ENG-SF19014-R4-MDDP-Redlines.pdf Markup Summary

ENG-SF19014-R4-CD-Redlines.pdf Markup Summary

ENG-SF19014-R4-GEC-Redlines.pdf Markup Summary

BOX CULVERT PLAN & PROFILE

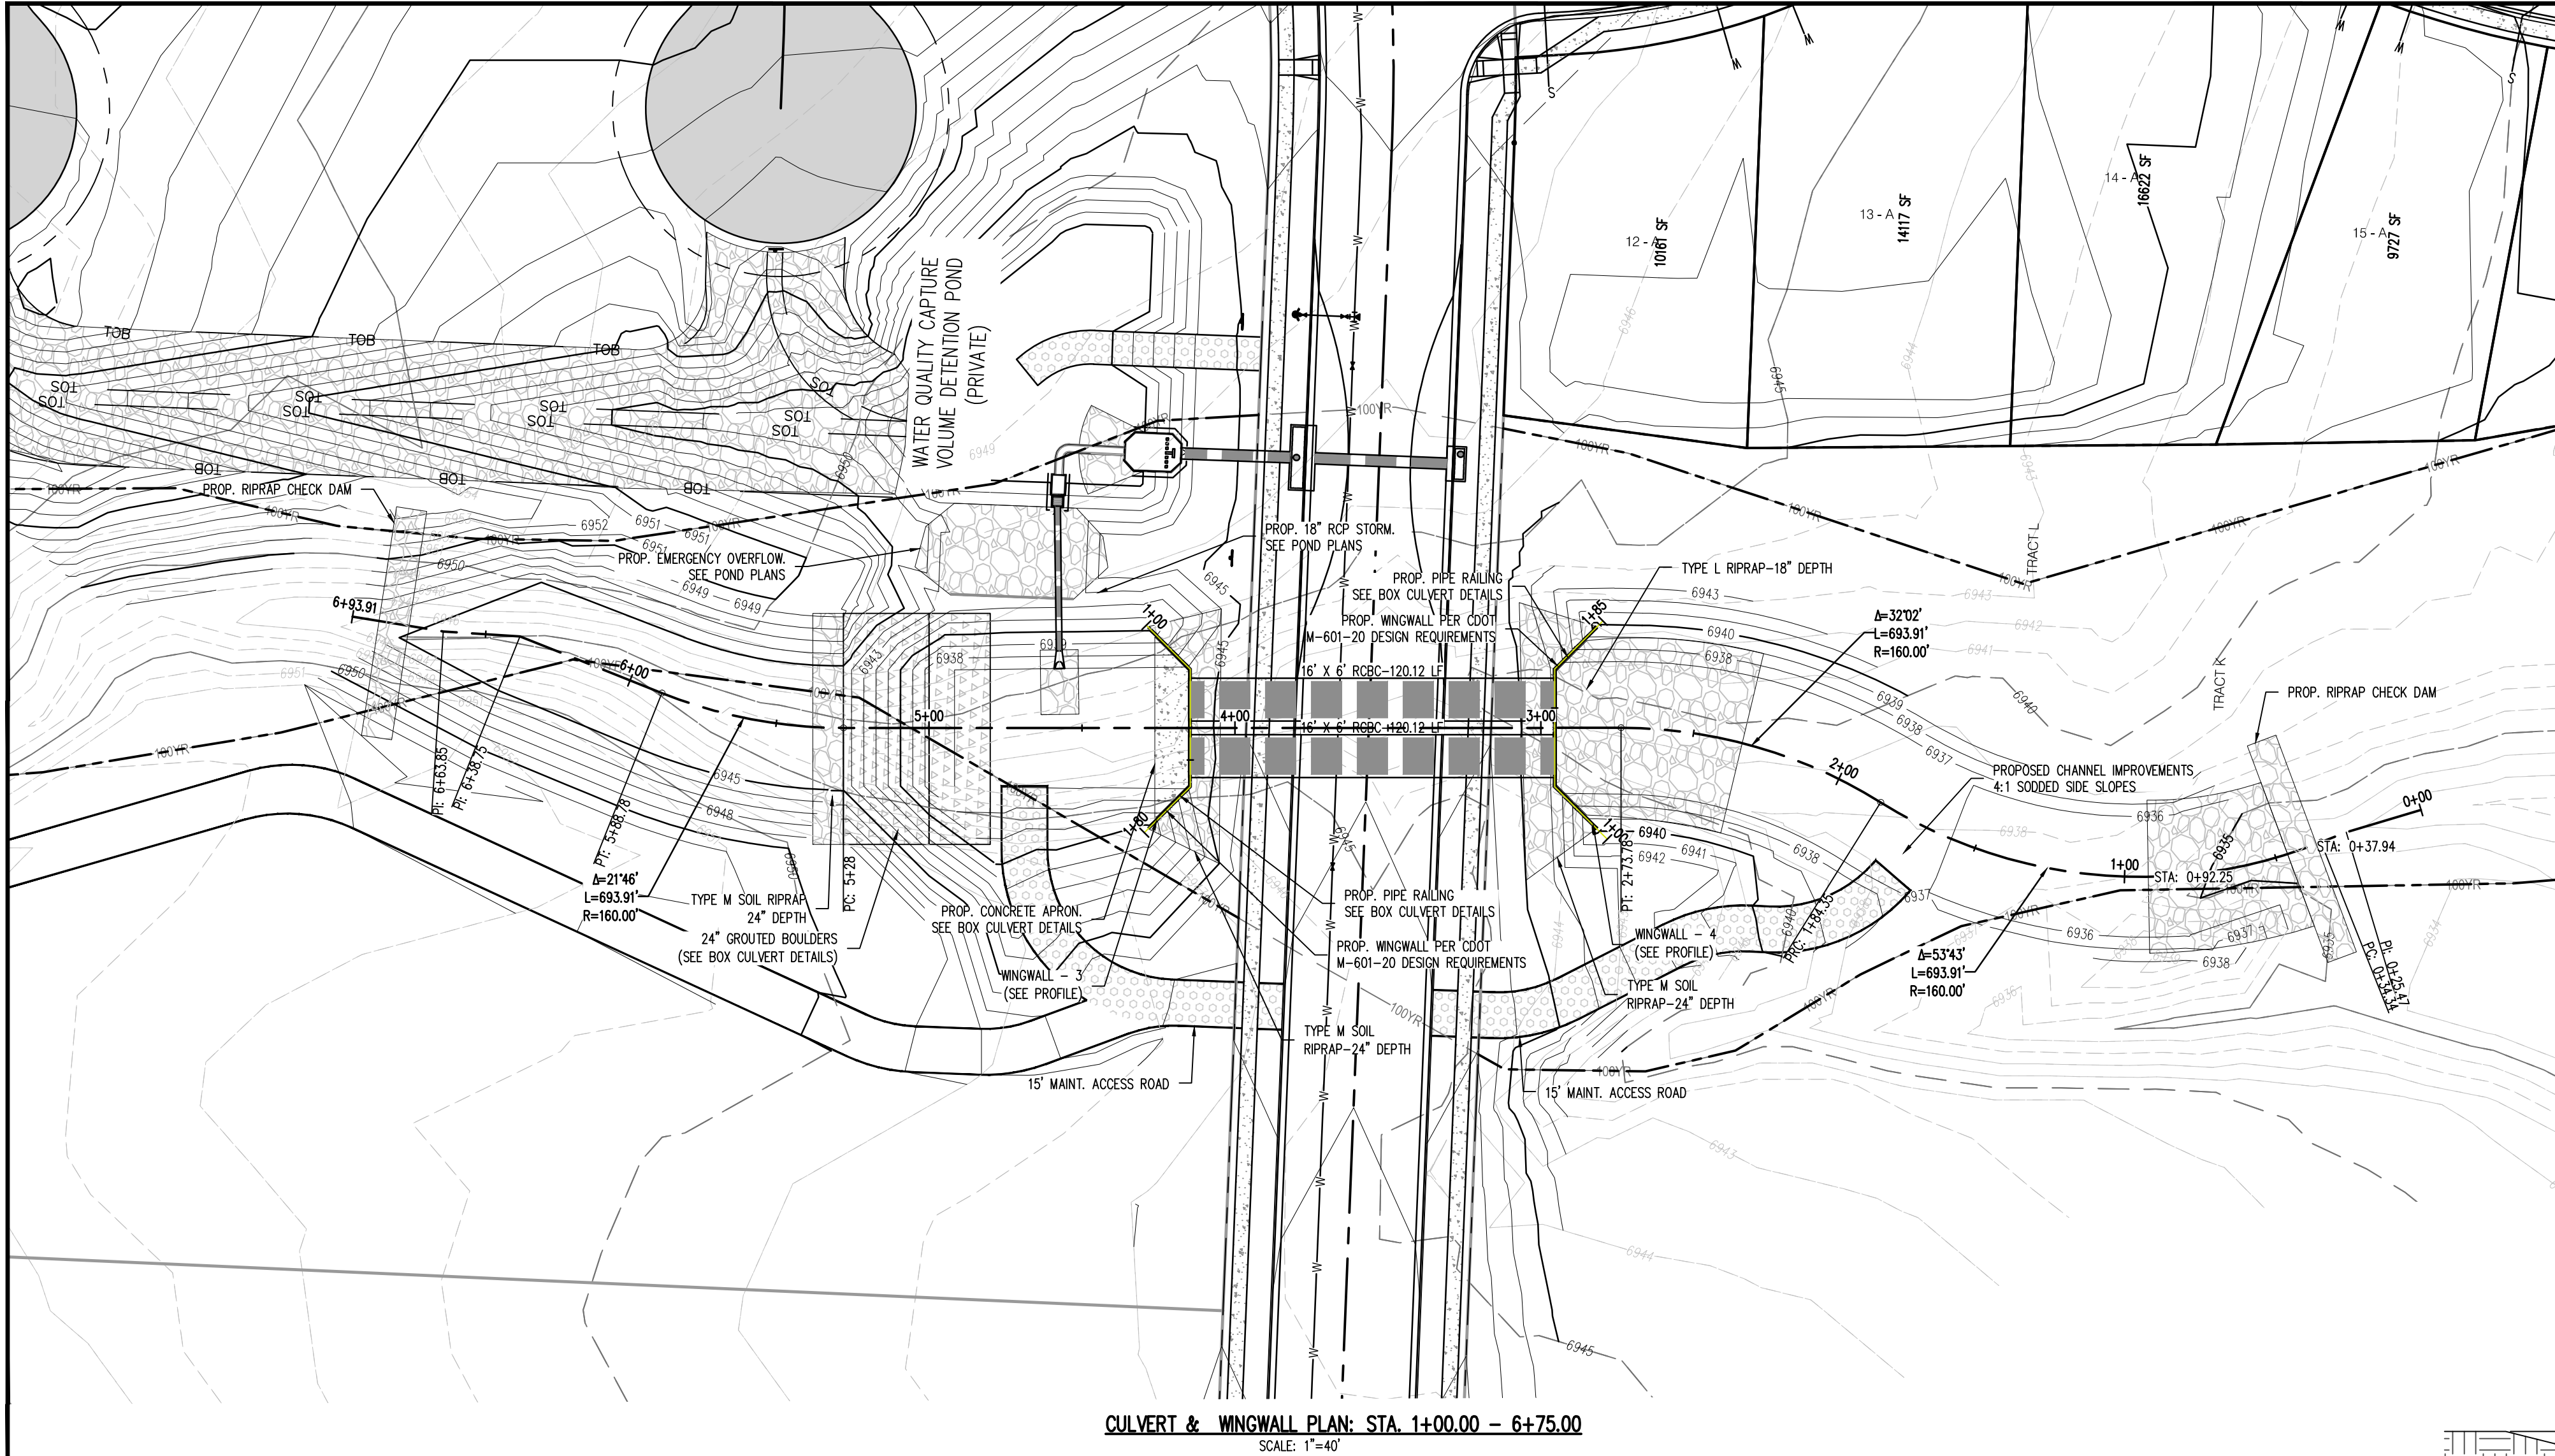
What is the grade, velocity, etc.? It appears that a check structure is necessary.

CULVERT CHANNEL TYPICAL SECTION
SCALE: 1"=10'

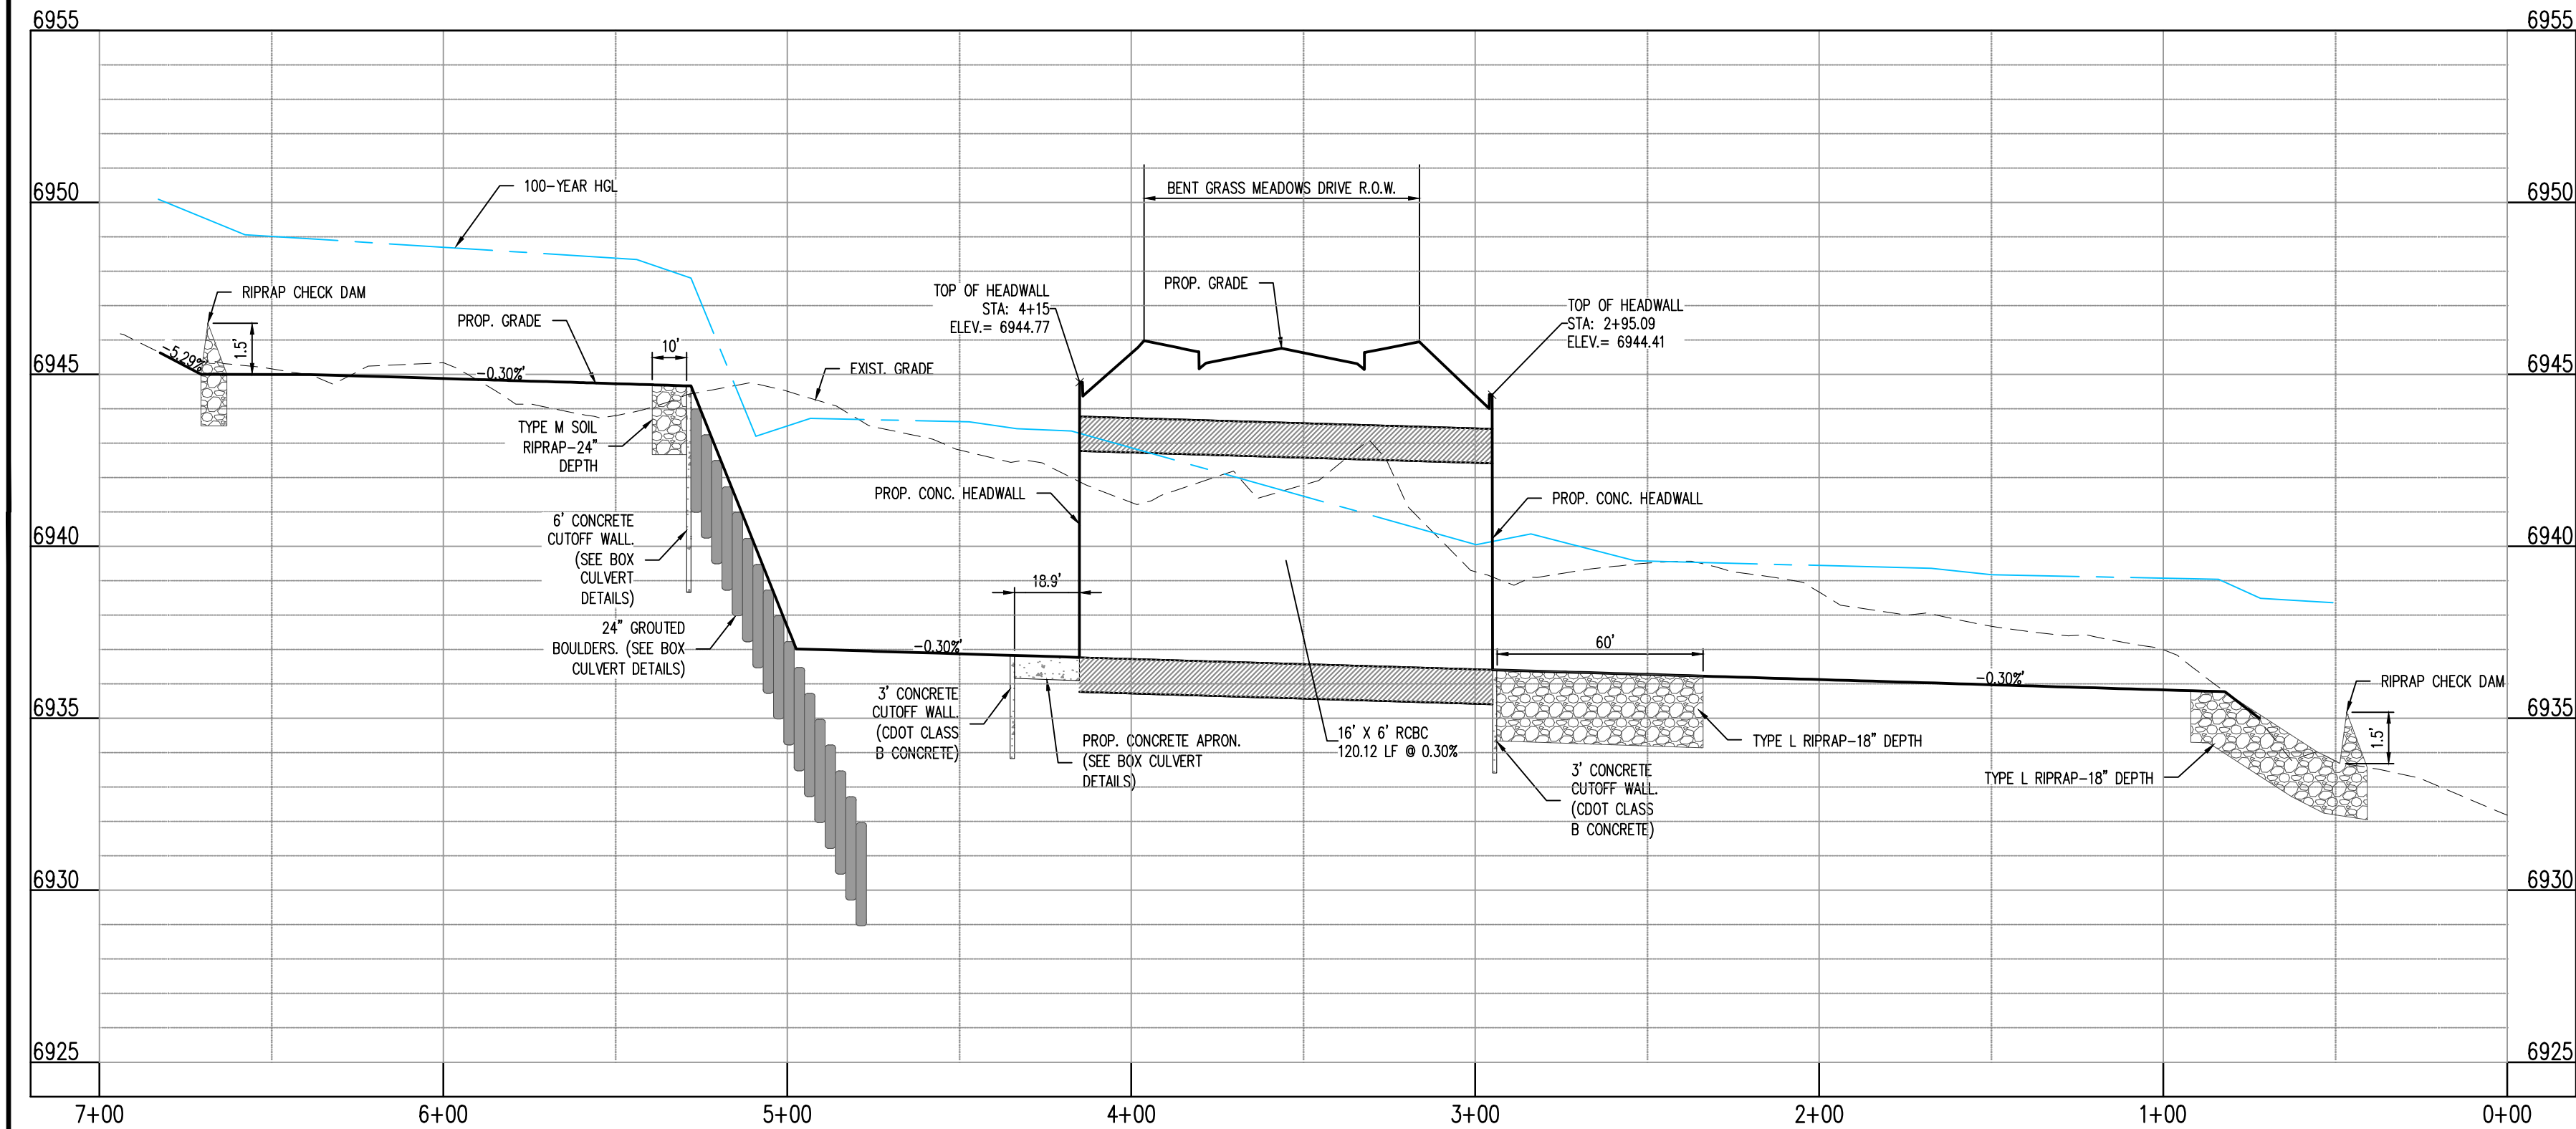
It appears that additional channel stabilization is required here. (4400 in model)

What is the grade, velocity, etc.? It appears that a check structure is necessary.

erosion protection?

Label grade.
